North Northamptonshire Council

Responses to ExA Questions 2

PINS Reference EN010170

Proposal (summary): An application for a Development Consent Order to construct, operate, maintain and decommission the Green Hill Solar Farm

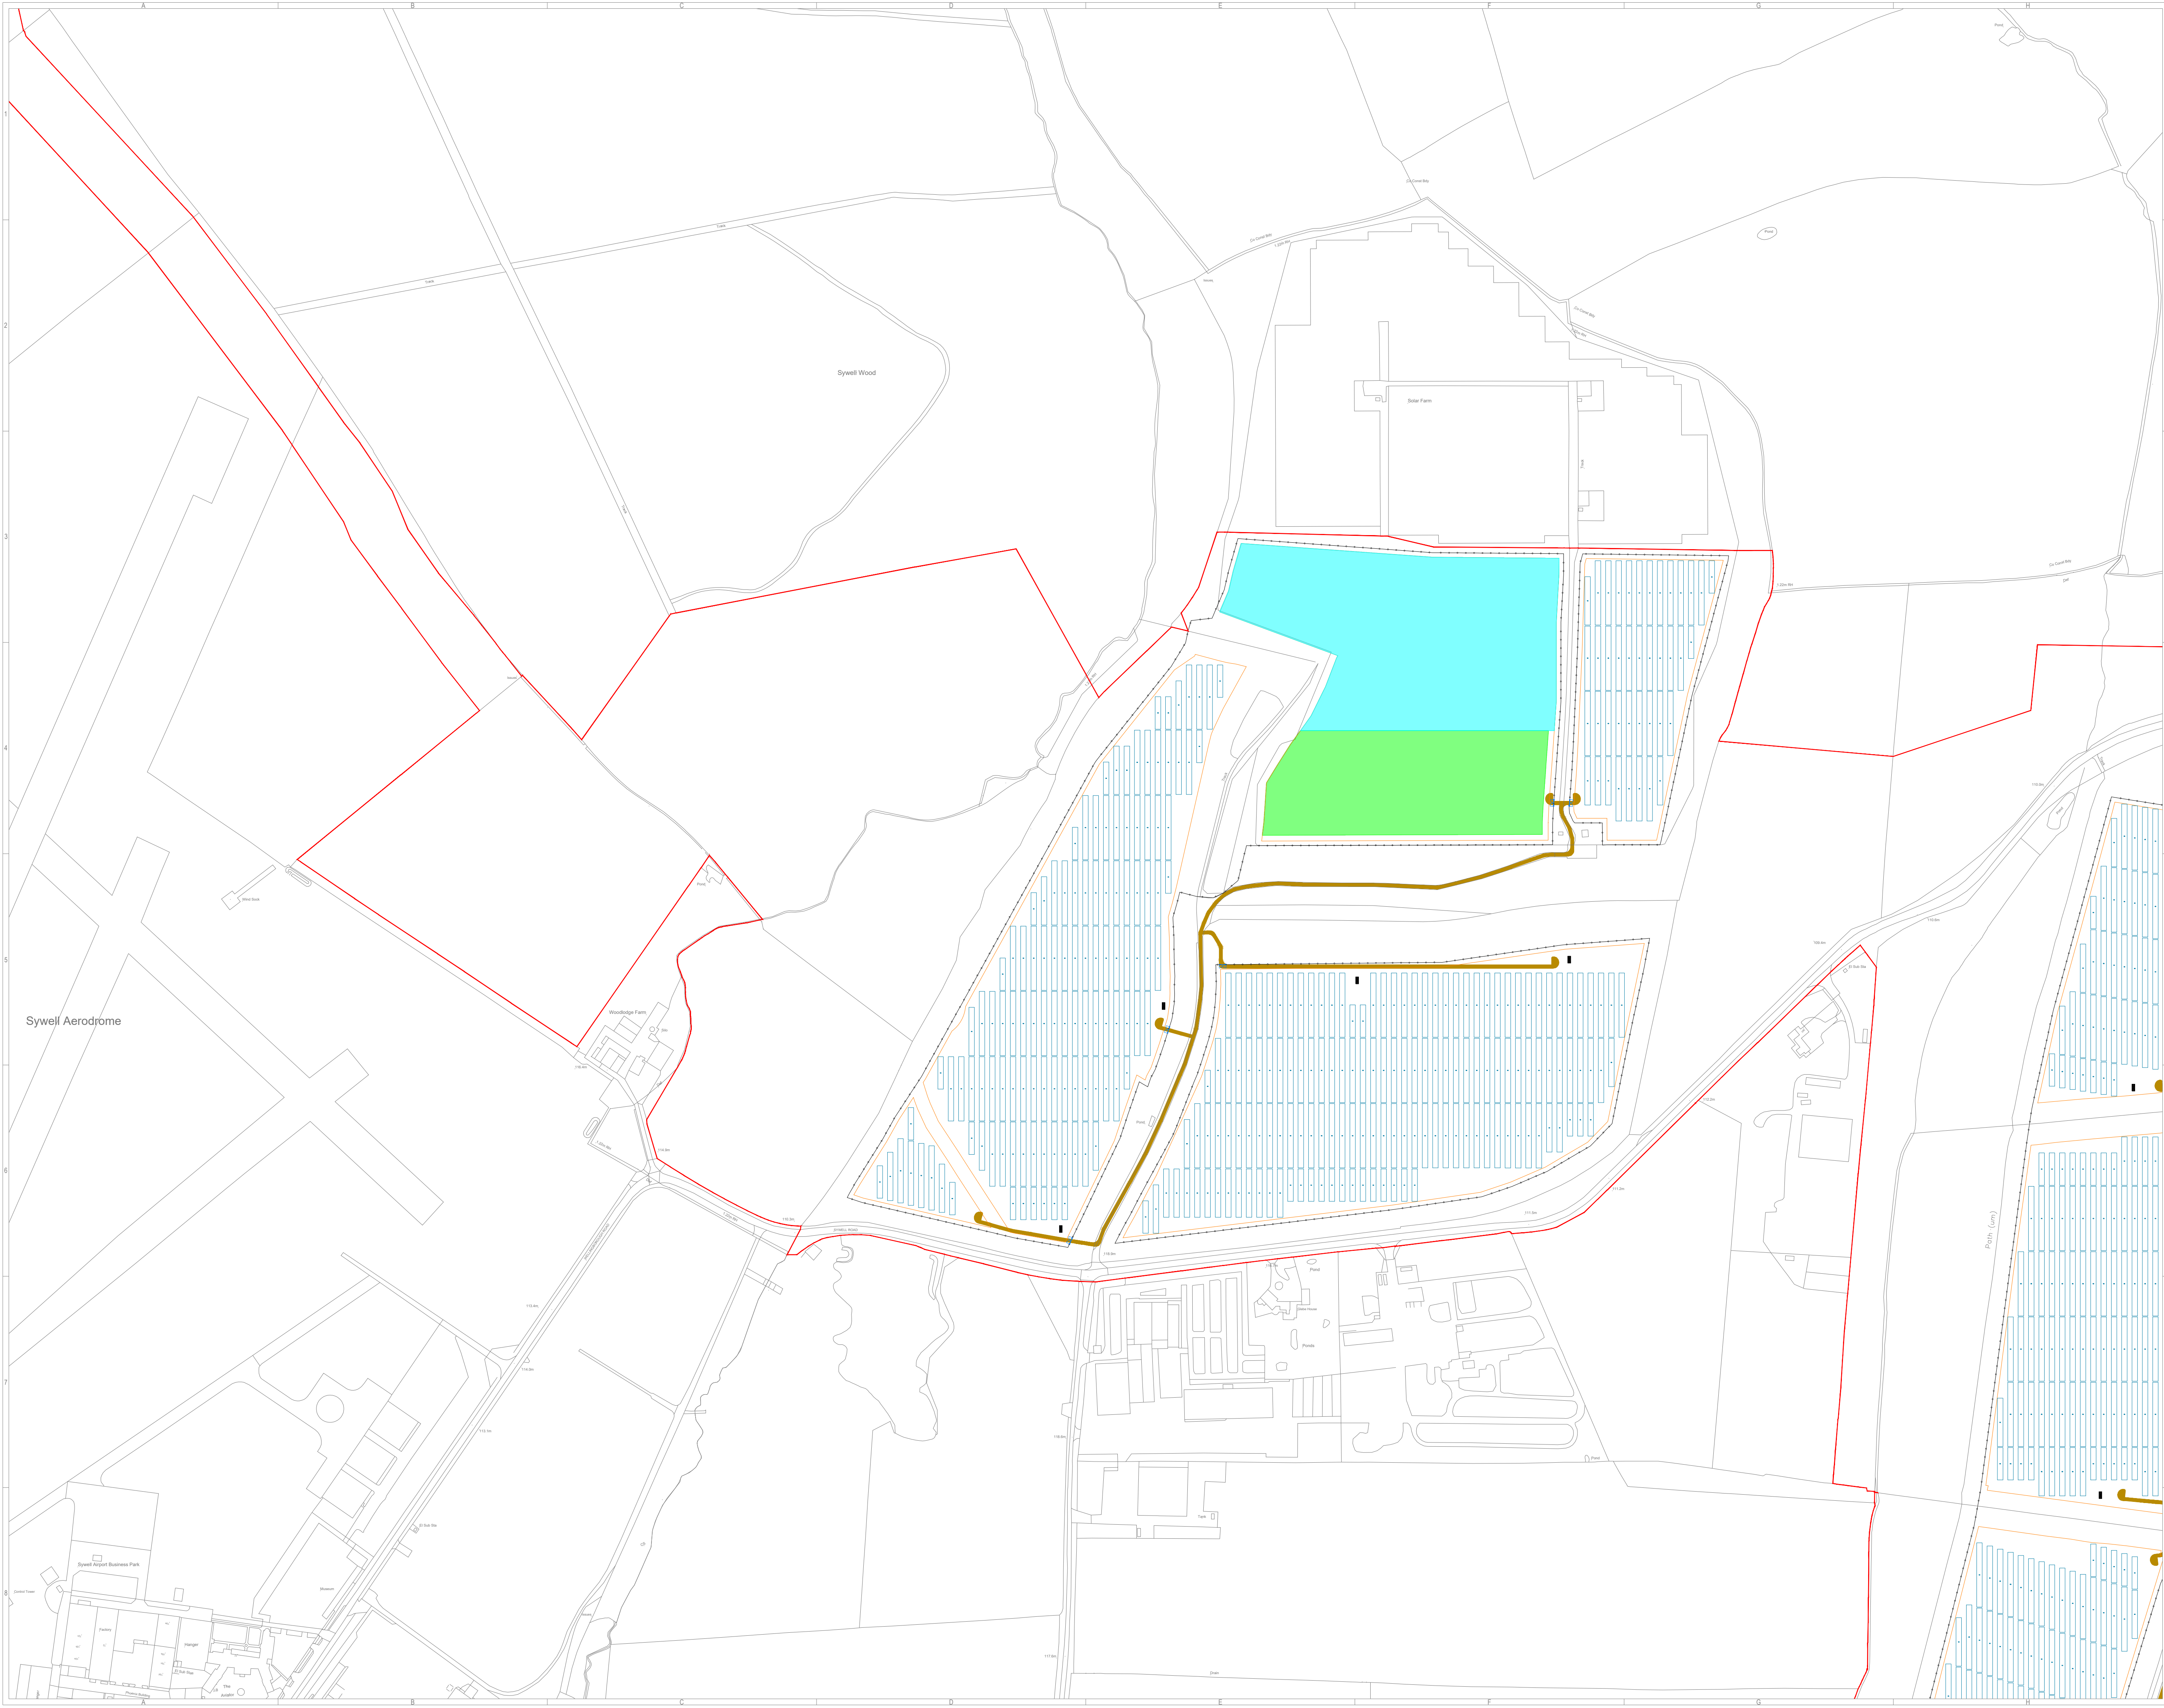
NNC Response – Having reviewed the Illustrative Layout Plans (APP-196 & APP-197, and APP-200), NNC are content to agree that the three NHDAs identified (Woodlodge Farm, Hockerhill Farm and Ward's Barn) are outside of the Order Limits.

Title: Figure 8.3.4 Landform
Green Hill F & BESS

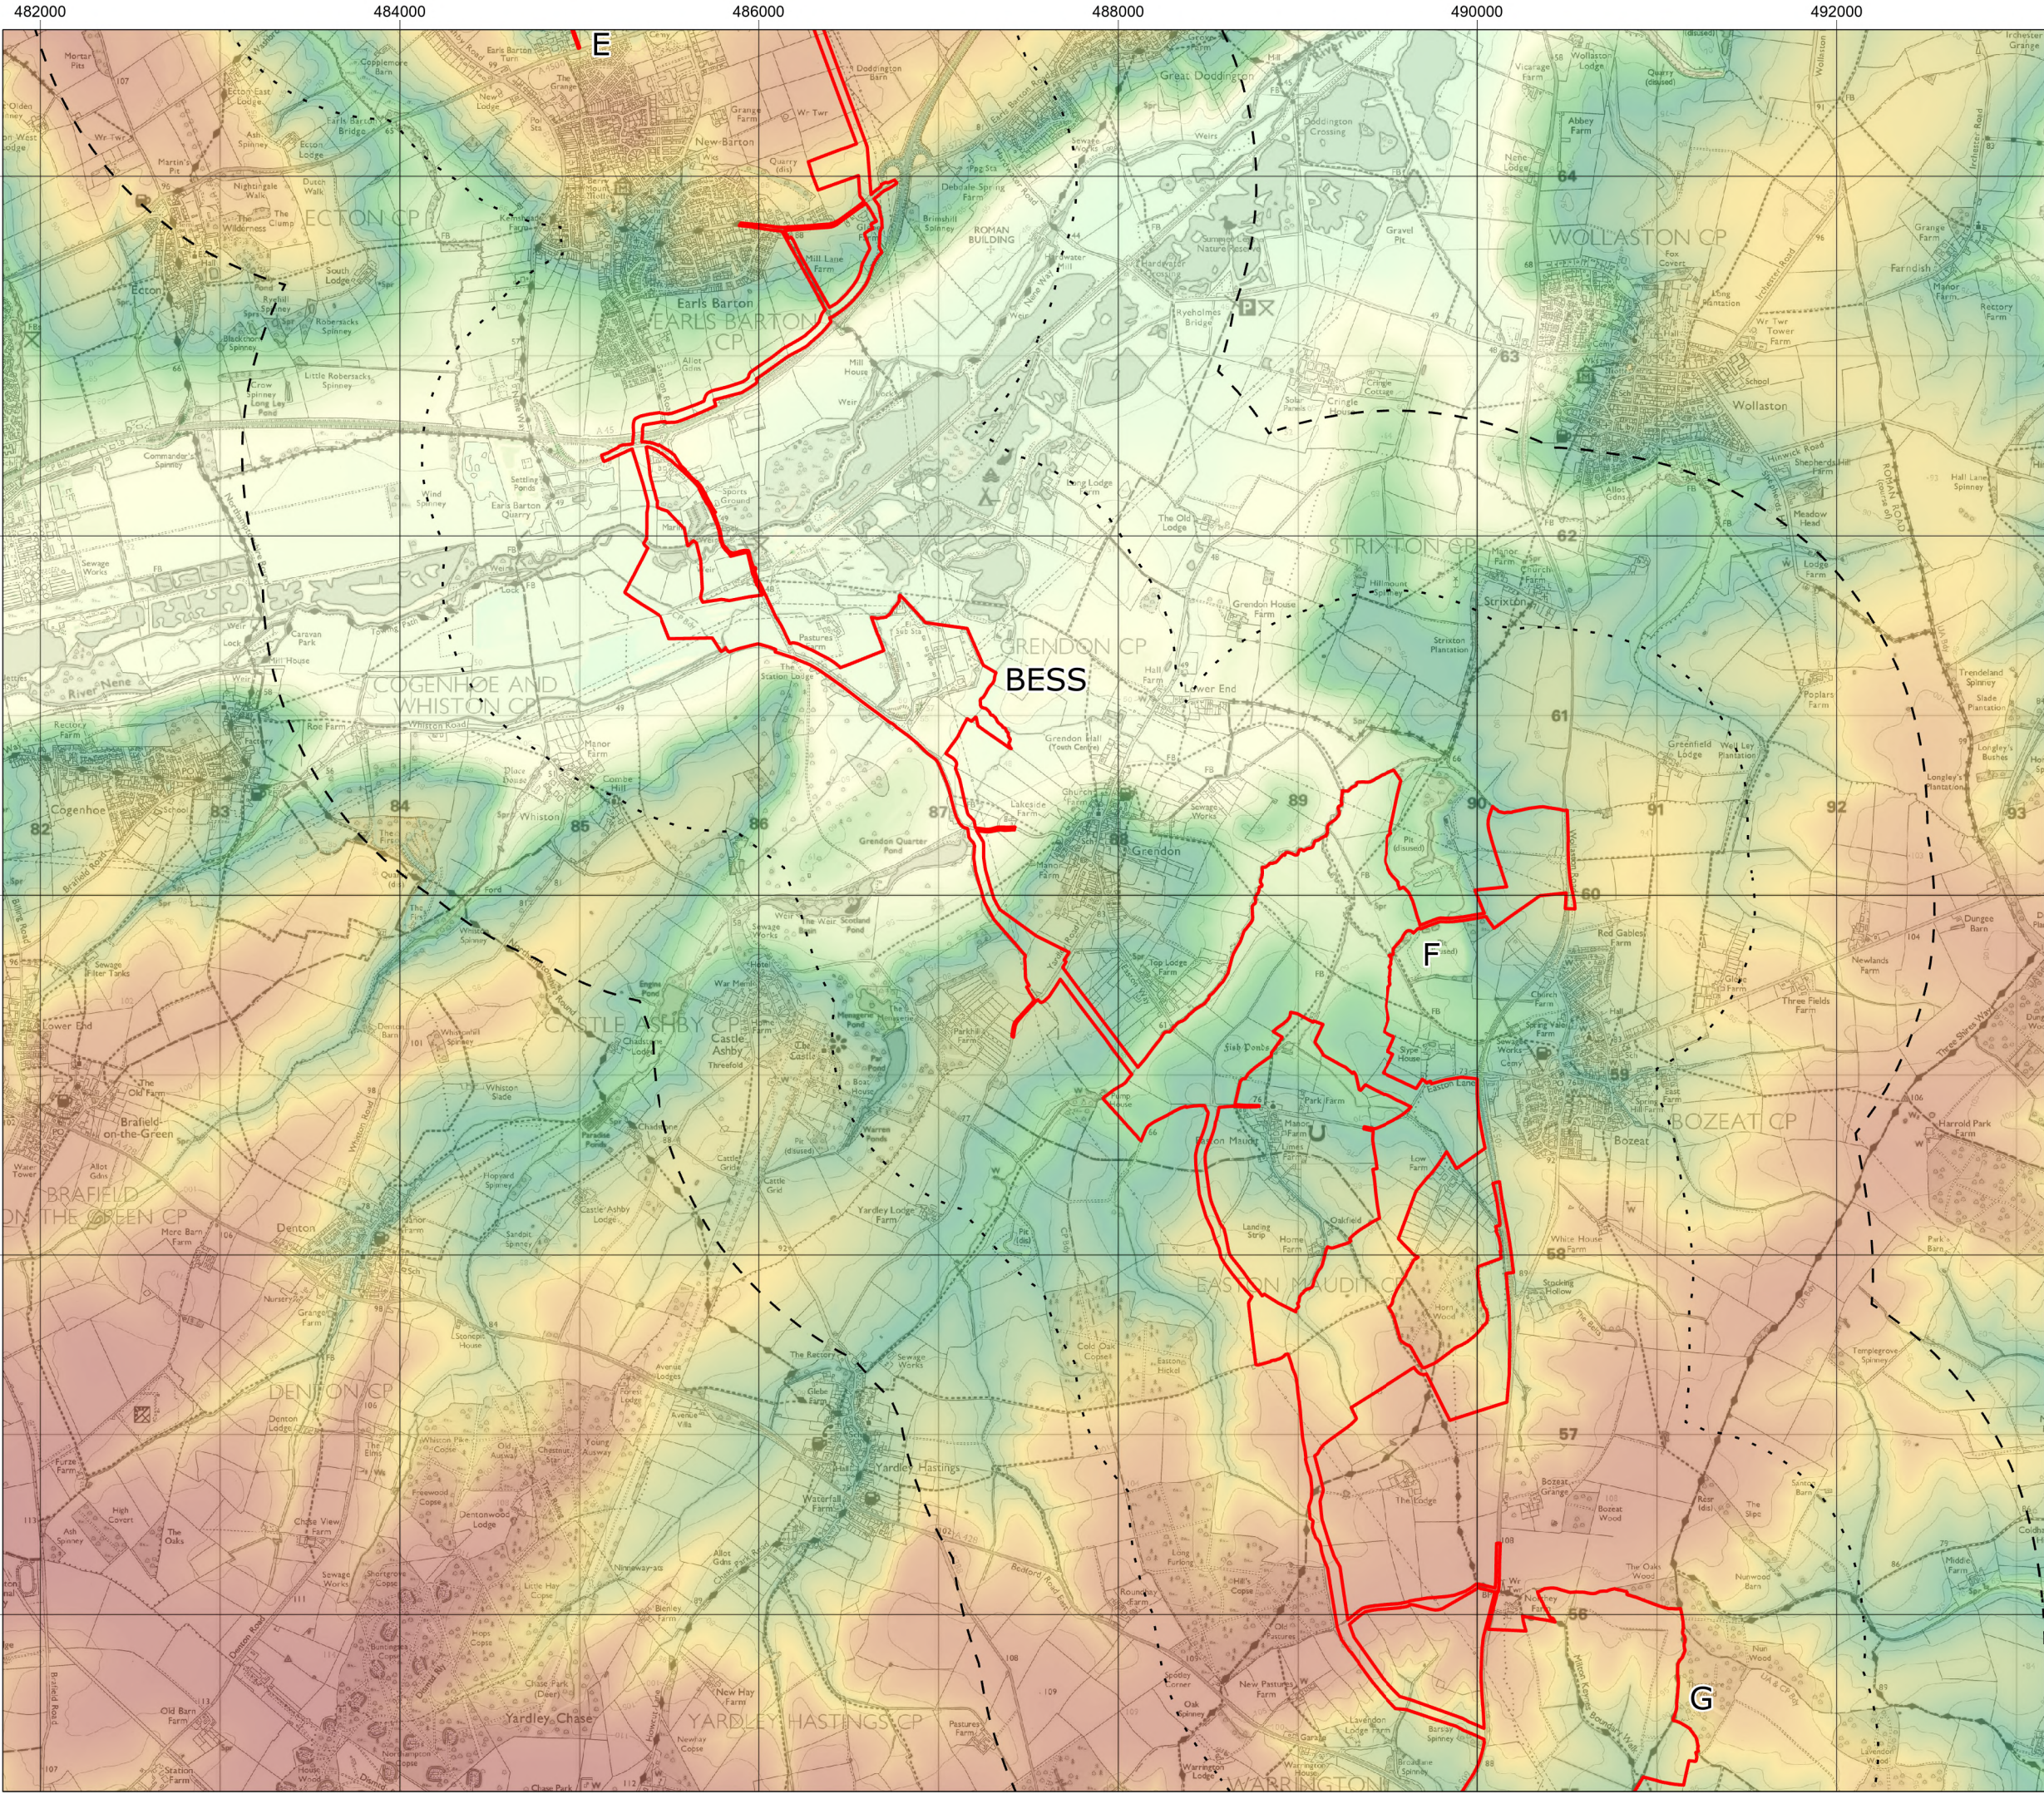
For example, Site F exhibits more noticeable topographic variation than many of the other sites, resulting in a landscape where changes in land use are more readily appreciable within the wider character area, even if the effects are not always visually prominent from public viewpoints. In contrast, Site E, while not visually exposed due to the absence of PRoW, nonetheless has a clear and established relationship with surrounding farmland, meaning that a shift in land use from agriculture to energy infrastructure would still alter the character of that area in a meaningful way.
